CITY OF ALBUQUERQUE

May 30, 2023

Re: Champion Xpress Car Wash
9640 Universe Blvd. NW
30-Day Temporary Certificate of Occupancy
Transportation Development Final Inspection
Engineer's Stamp dated 06-01-22 (B10-D003J)
Certification dated 05-11-23

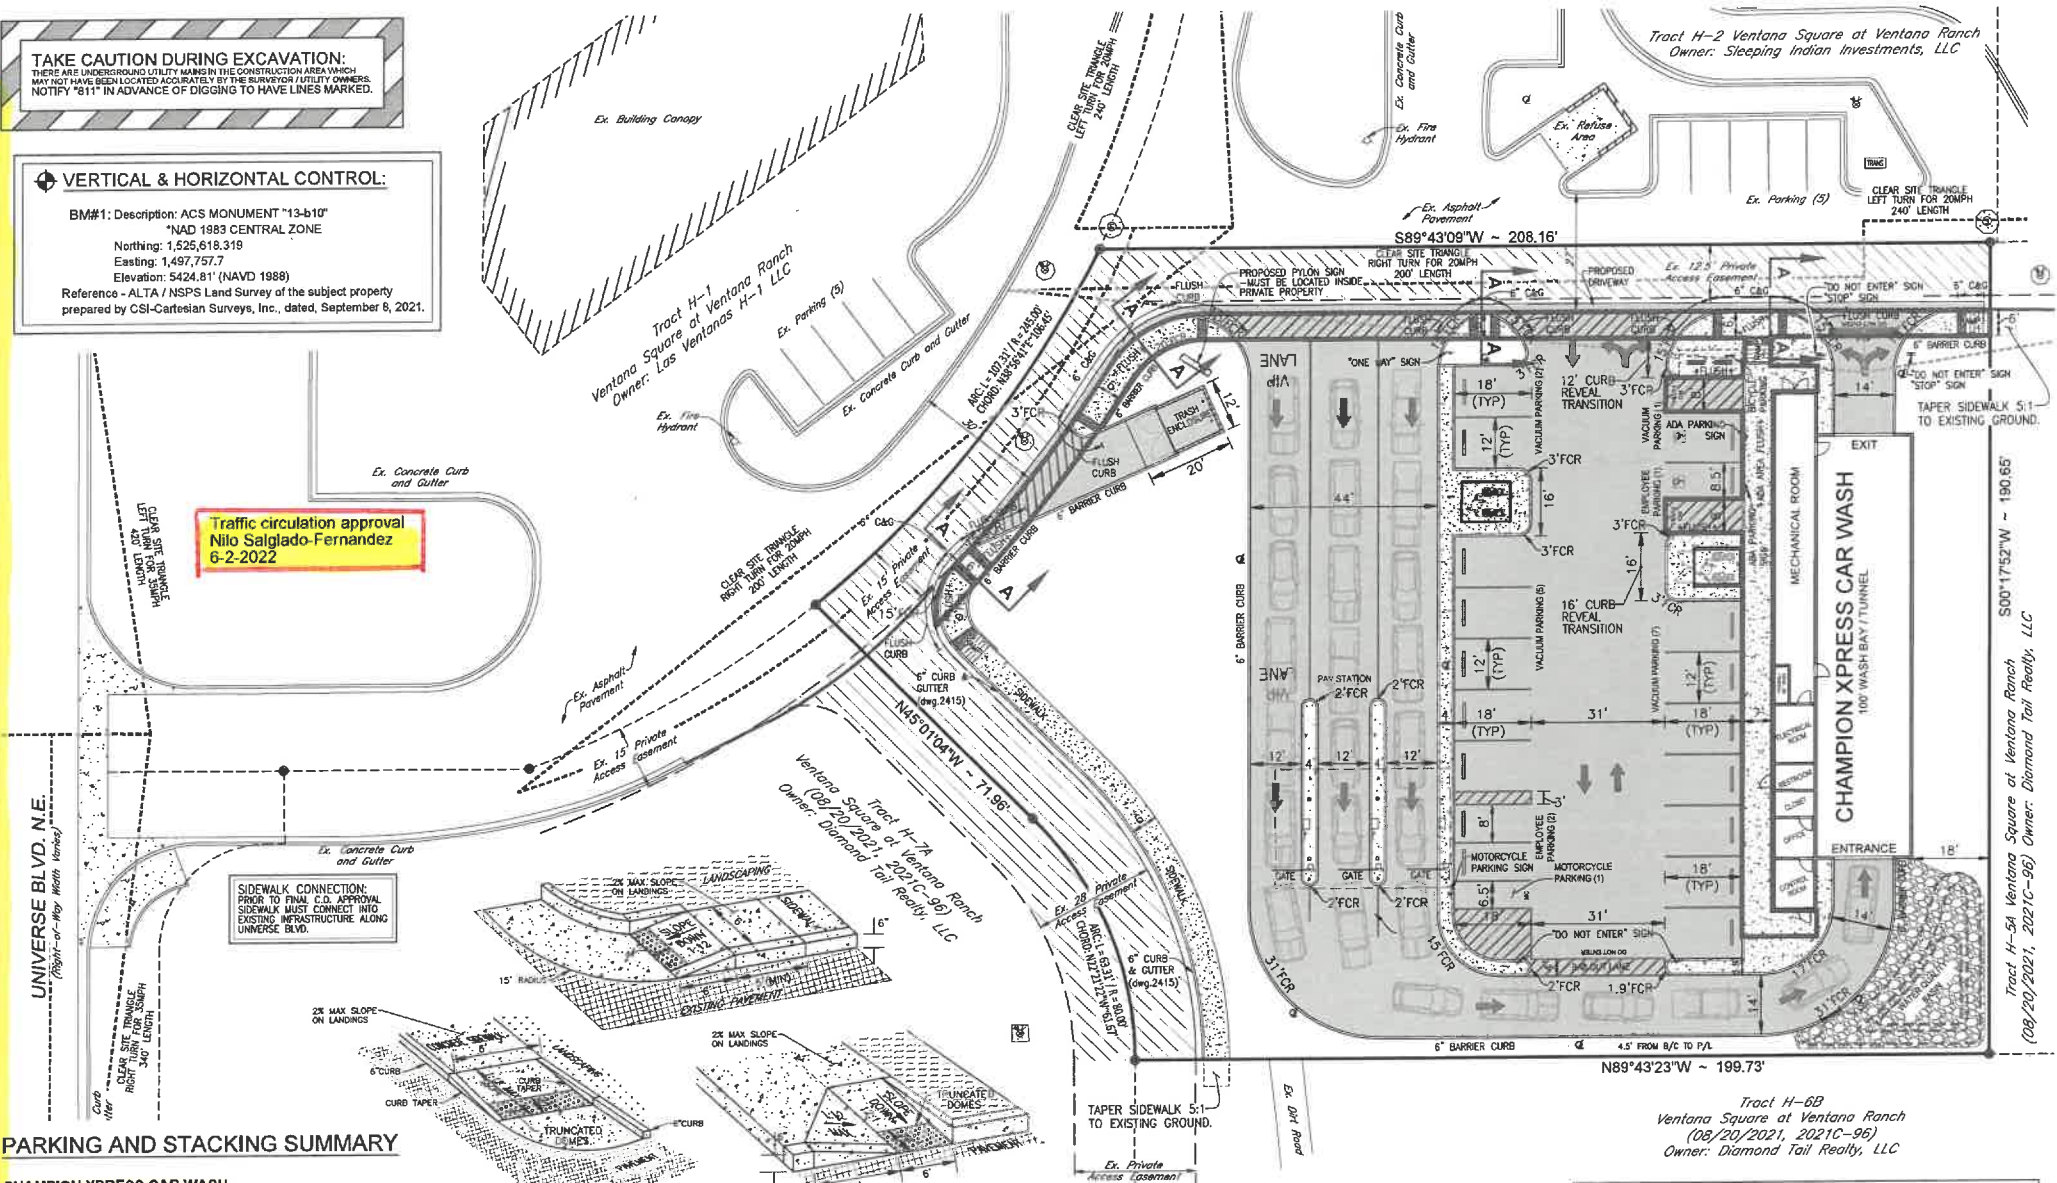
- Per approved plans, Sidewalk and connection to Universe on Tract H-7A must be completed and approved.
- Work order number 670982, must be completed and approved.
- Parking lot lines should be painted with white color only.
